**From:** Cruse & Associates <cruseandassoc@kvalley.com>  
**Sent:** Thursday, September 05, 2013 11:37 AM  
**To:** Doc Hansen; Jeff Watson  
**Cc:** Kirk Holmes; Doug D'Hondt  
**Subject:** Happy Trails

HAPPY TRAILS
SECTION 6, T. 17 N., R. 19 E., W.M.
KITITAS COUNTY, WASHINGTON
- PRELIMINARY PLAT -

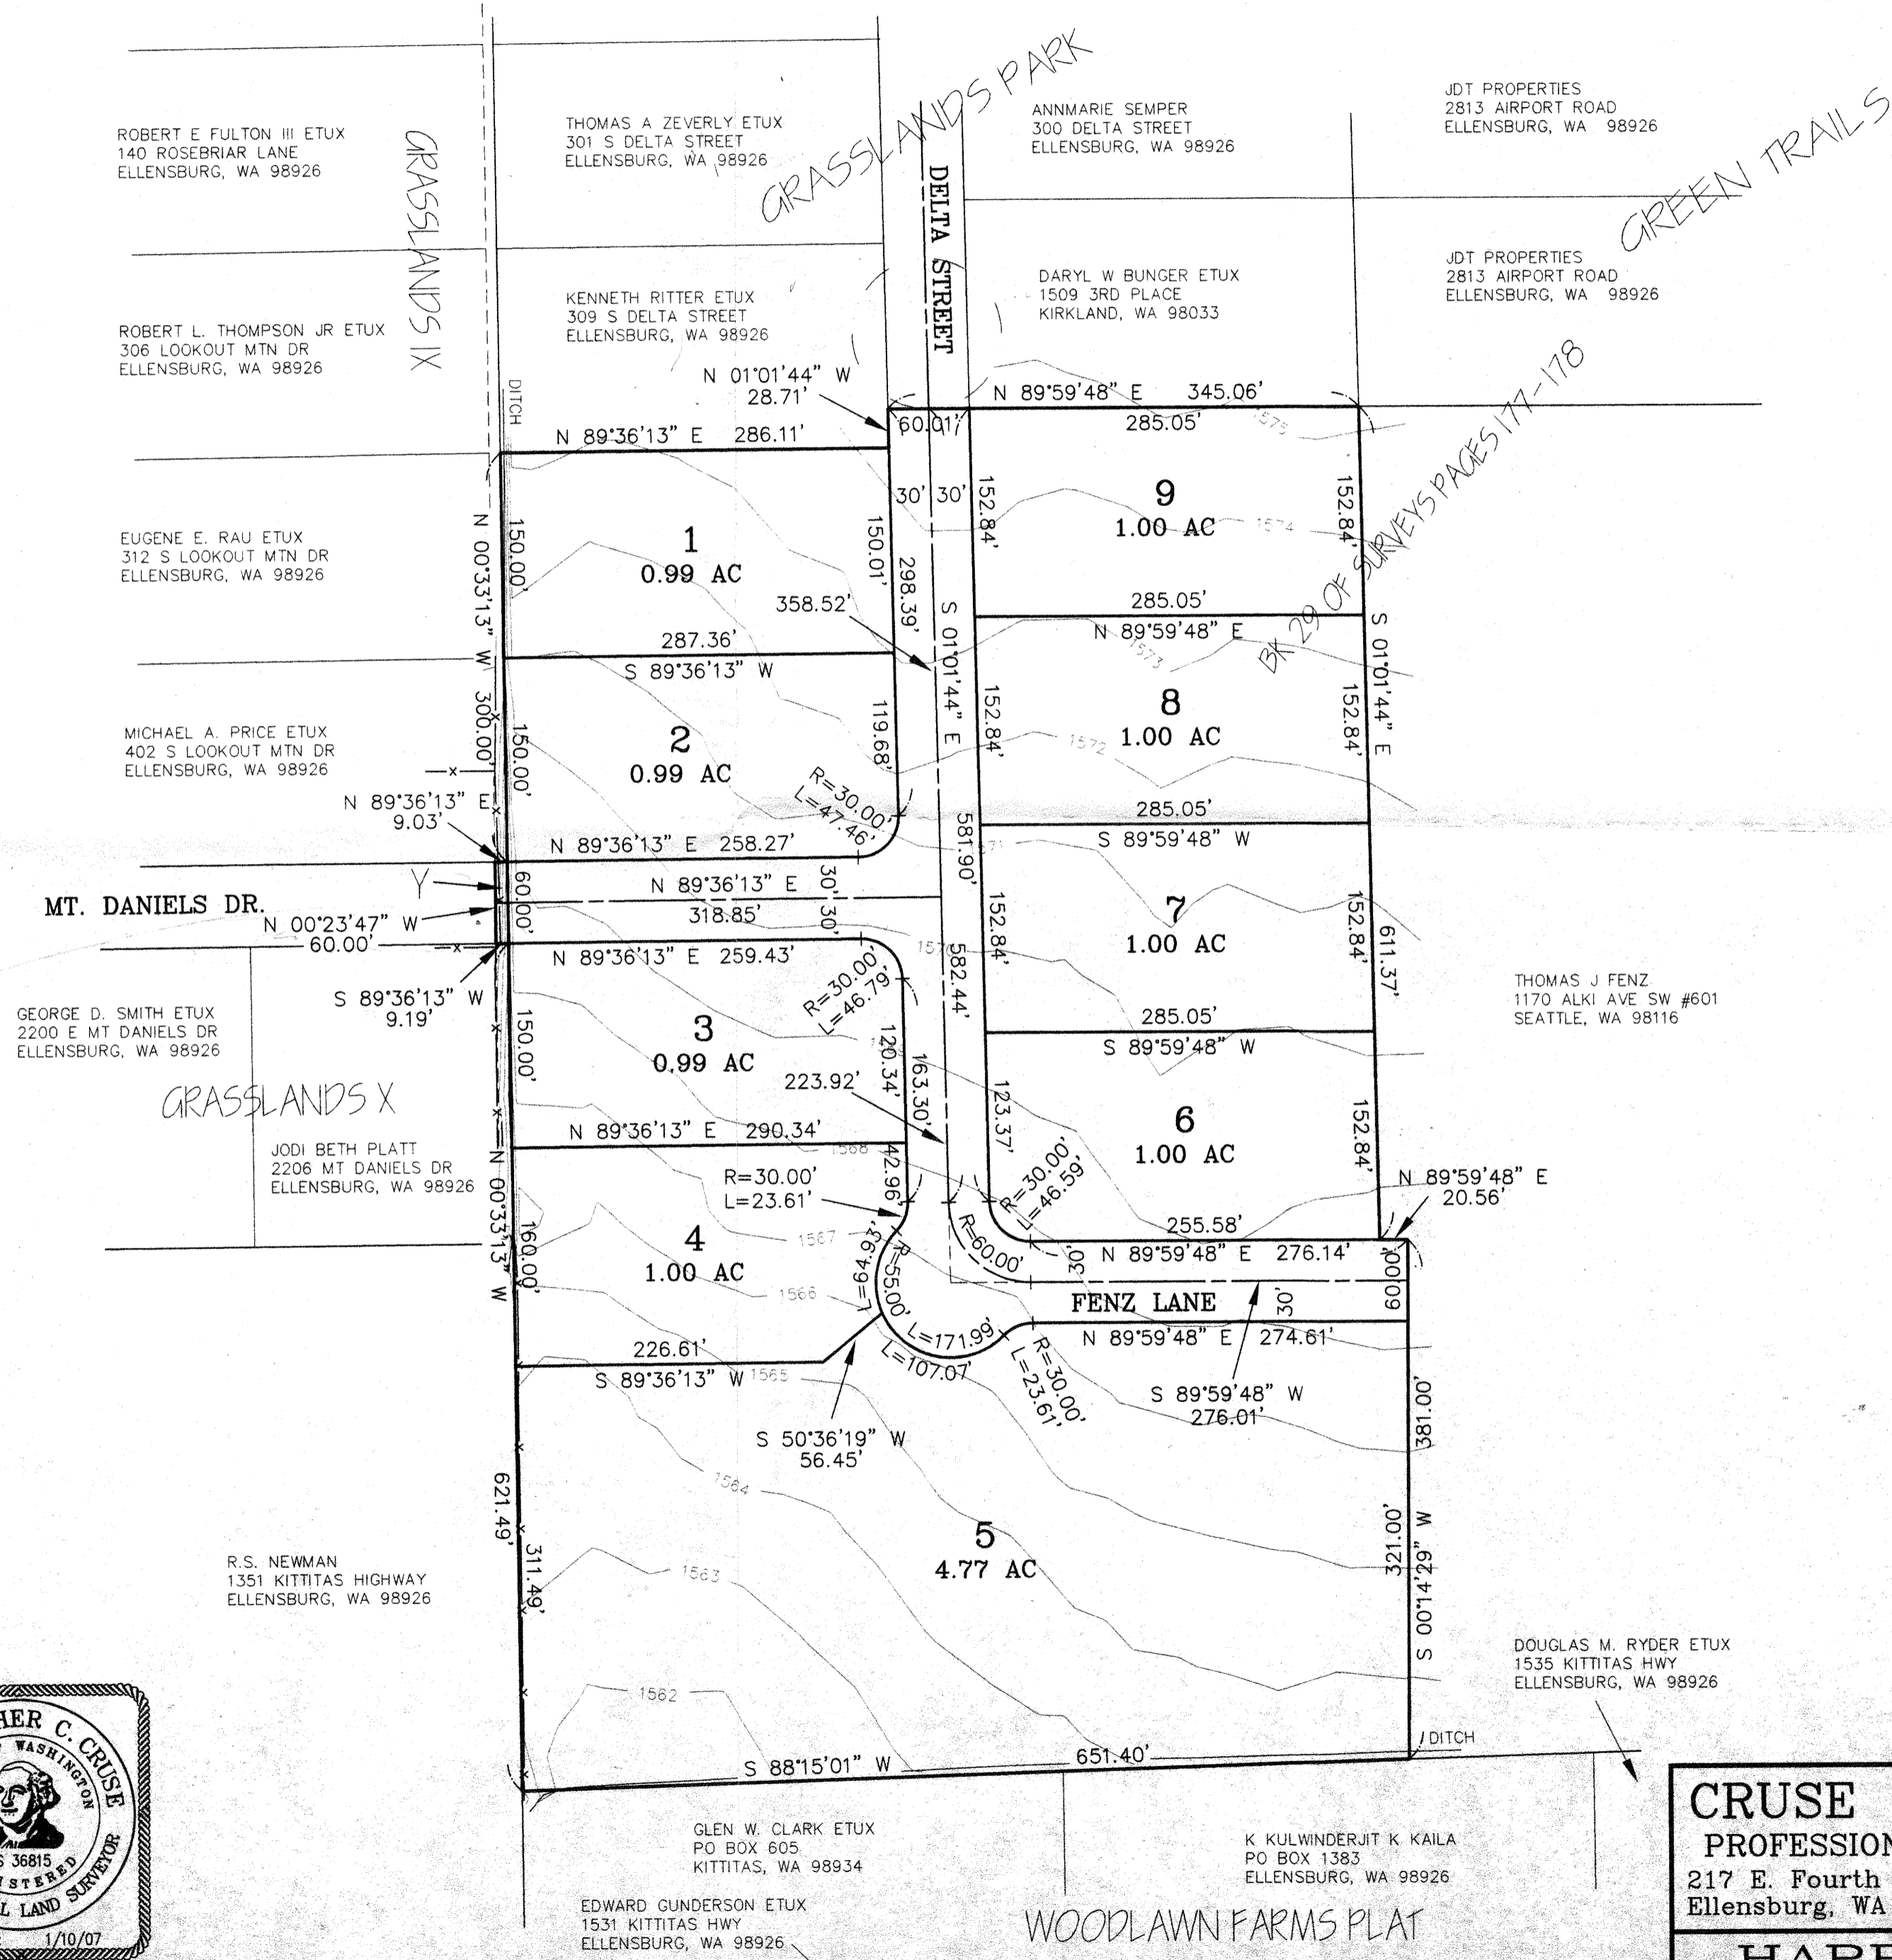
I have reviewed the file and following up on our discussion regarding the construction of Mt. Daniels Dr. for the plat of Happy Trails. During our initial pre-app meeting we proposed a number of access routes into this neighborhood. During these meetings we were told that PW would not allow access to Kittitas Hwy and No. 6 road as it would allow motorists to cut through Grasslands instead of using the main arterials and overburden the existing Grasslands road system. As we submitted plats we started constructing Quartz Mt. Dr. and working our way east and south to the plat of Happy Trails.

Based on previous meetings we submitted Happy Trails in 8/2006 expecting that construction of Mt Daniels Dr would be required for final approval. During the review process it became apparent that conflicts in the existing right of way in Mt Daniels Dr. west of this application in the original plats of Grassland X would hinder construction. I was not involved with any discussions with the land owners along the original Mt Daniels Dr right of way but believe county staff ( Director of PW Bradshaw?) at that time reviewed the original right of way and met with the adjacent land owners. I was told due to the use and improvements of the adjoining land owners within the original right of way staff had determined that the conflicts were such that it was not feasible to actually construct the road. I was told that this application would be required to dedicate the right of way for Mt Daniels Dr but would not need to be constructed for approval of this plat. Staff at this time felt the traffic pattern for the area would be sufficient and the right of way for Mt Daniels Dr would be in place if needed for future construction.
